re: **Geotechnical Review of Grading Plans**
 Proposed Residential Development – Trails Edge – Stage 3
 298 Axis way – Ottawa, Ontario

date: November 10, 2025

file: PG2392-MEMO.02

CITY OF OTTAWA 298 AXIS WAY	MINTO COMMUNITIES INC.	PROJECT No. 240801
GRADING PLAN		DRAWING No. 240801-GR1

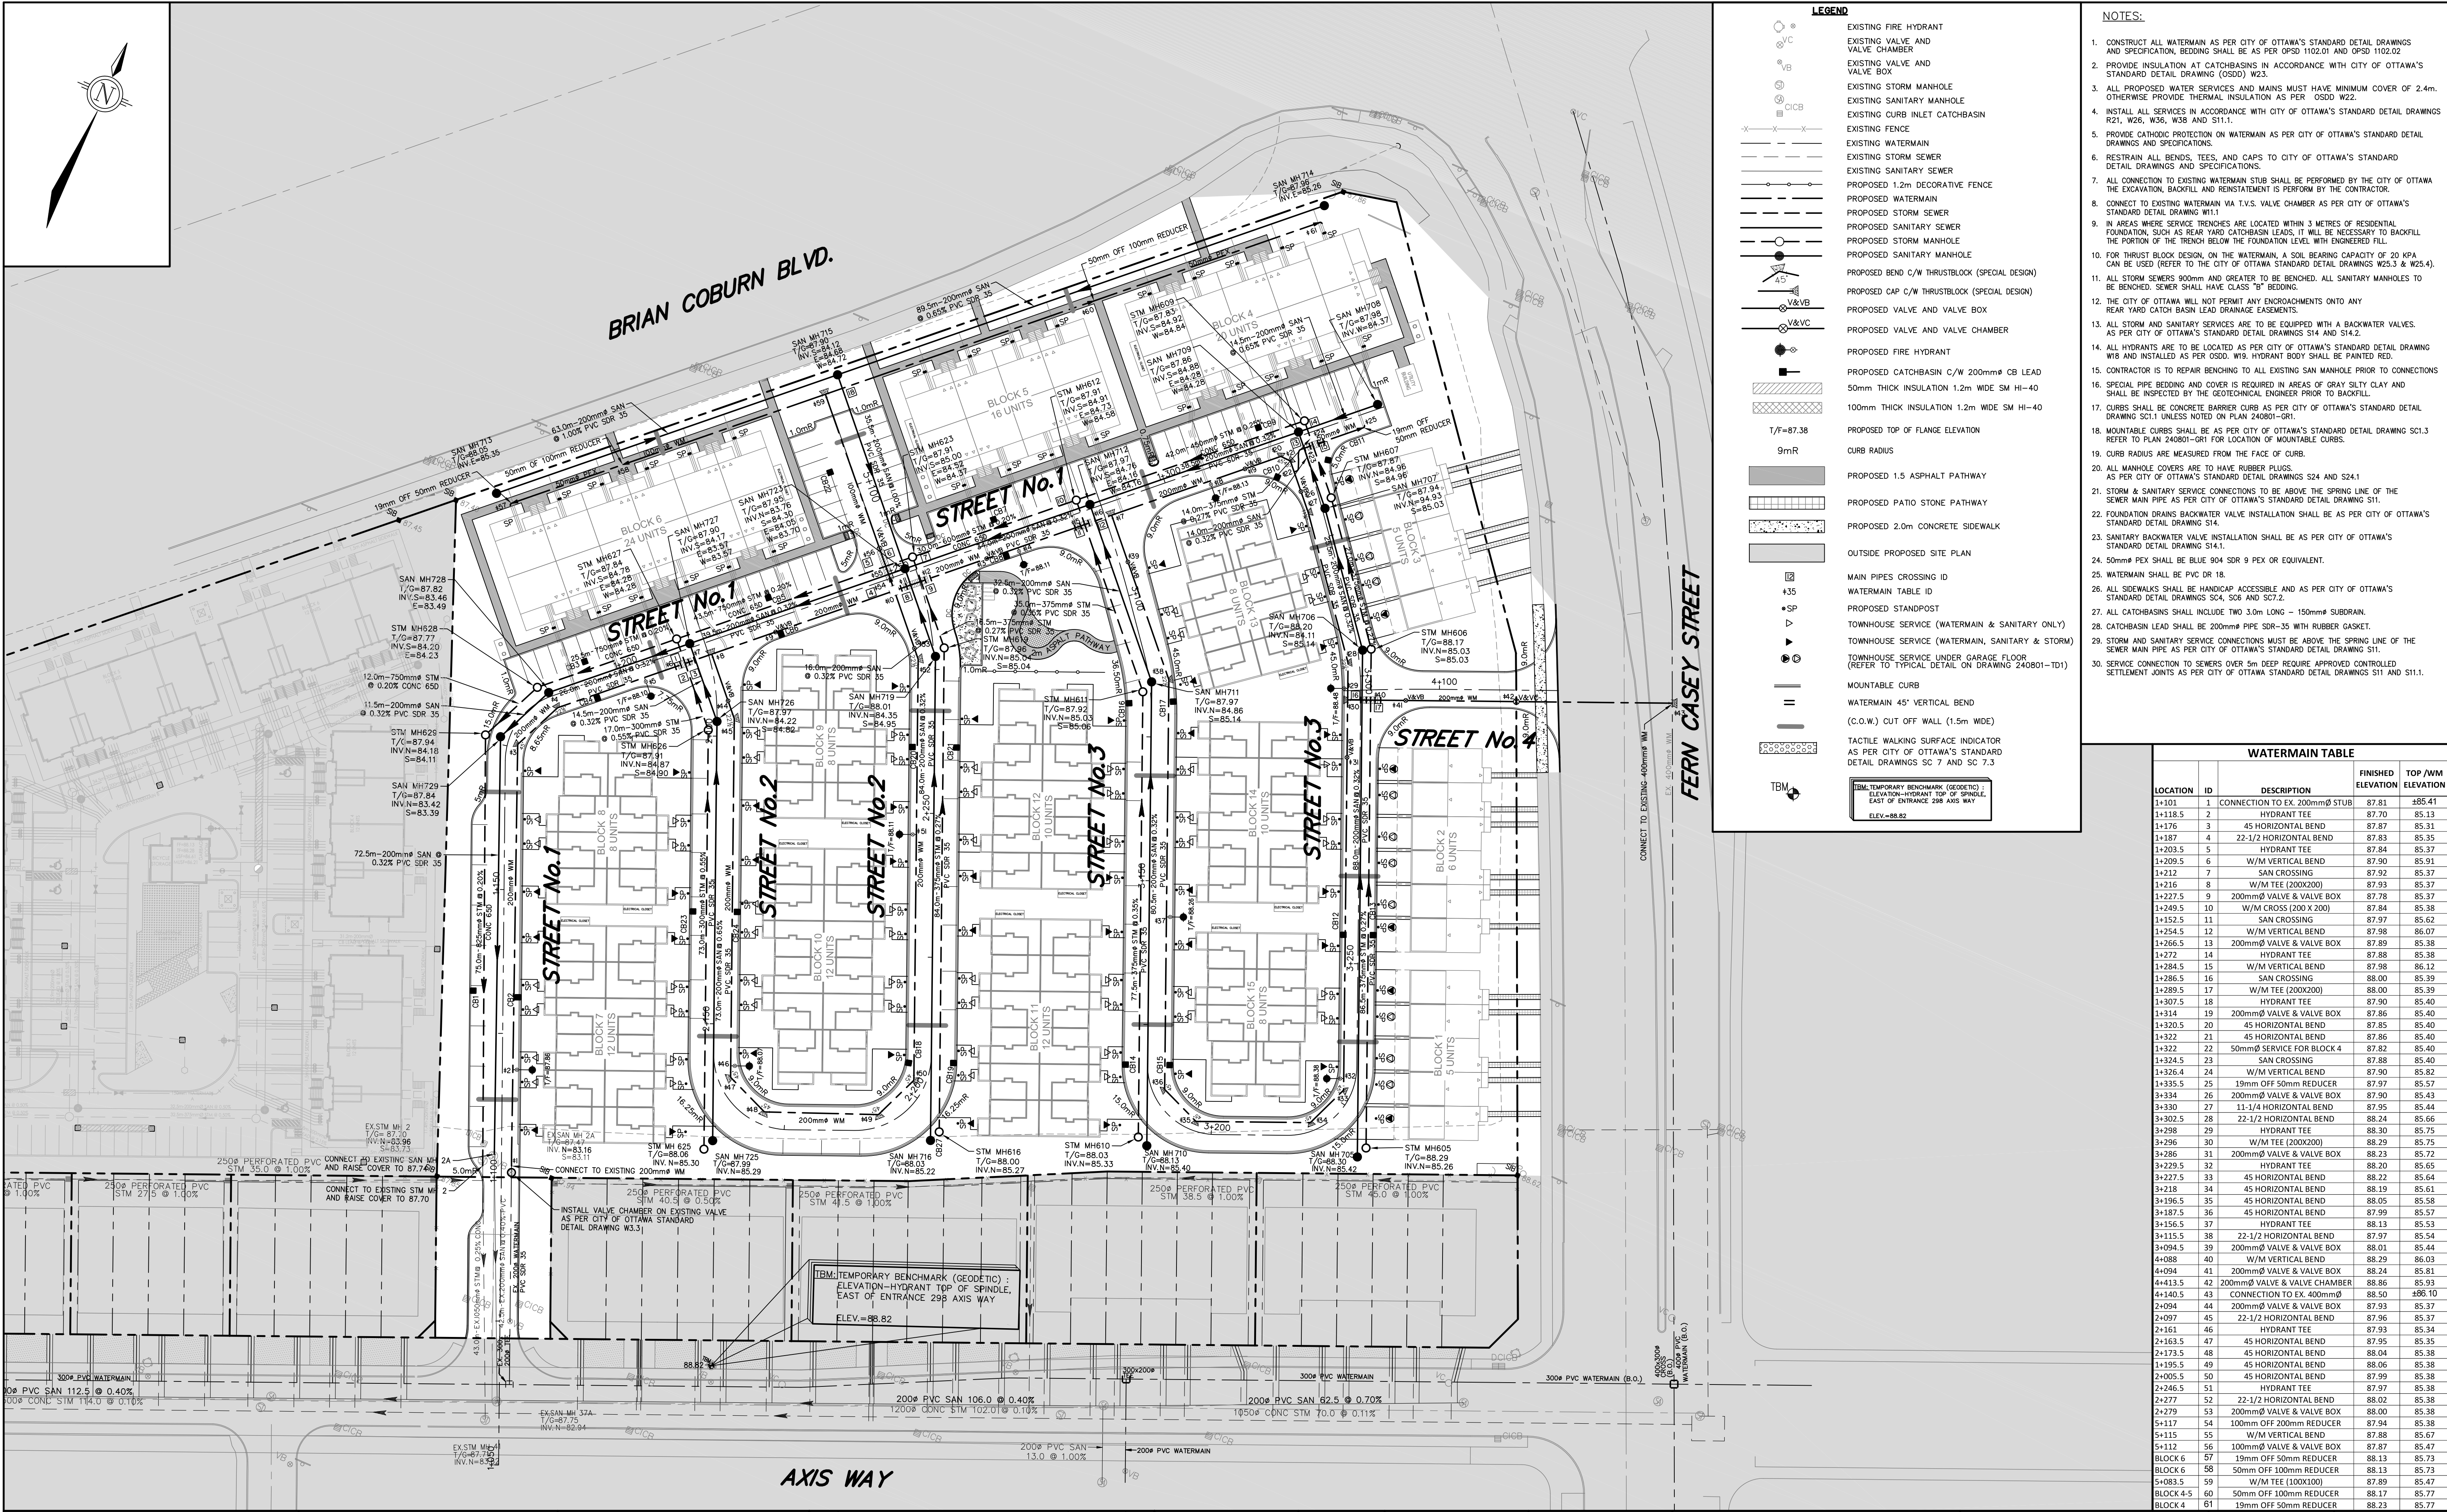
- ☐ Grading Plan - Project No. 240801 - Drawing No. 240801-GR1 - Received November 5, 2025

Based on our review of the above-noted drawing, a number of blocks/units of the subject site exceeded our permissible grade raise recommendations provided in the above-noted geotechnical report. Where significant grade raise exceedences have occurred, lightweight fill (LWF), such as expanded polystyrene (EPS) geofoam blocks are recommended for specific areas adjacent to the subject buildings. It should be noted that the proposed roadway grades throughout the subject site were found to be within the recommended permissible grade raise restrictions for roadways provided in the aforementioned geotechnical investigation report. Further, sufficient soil cover has been provided to perimeter and exterior pad footings to mitigate the migration of frost within the founding subsoils.
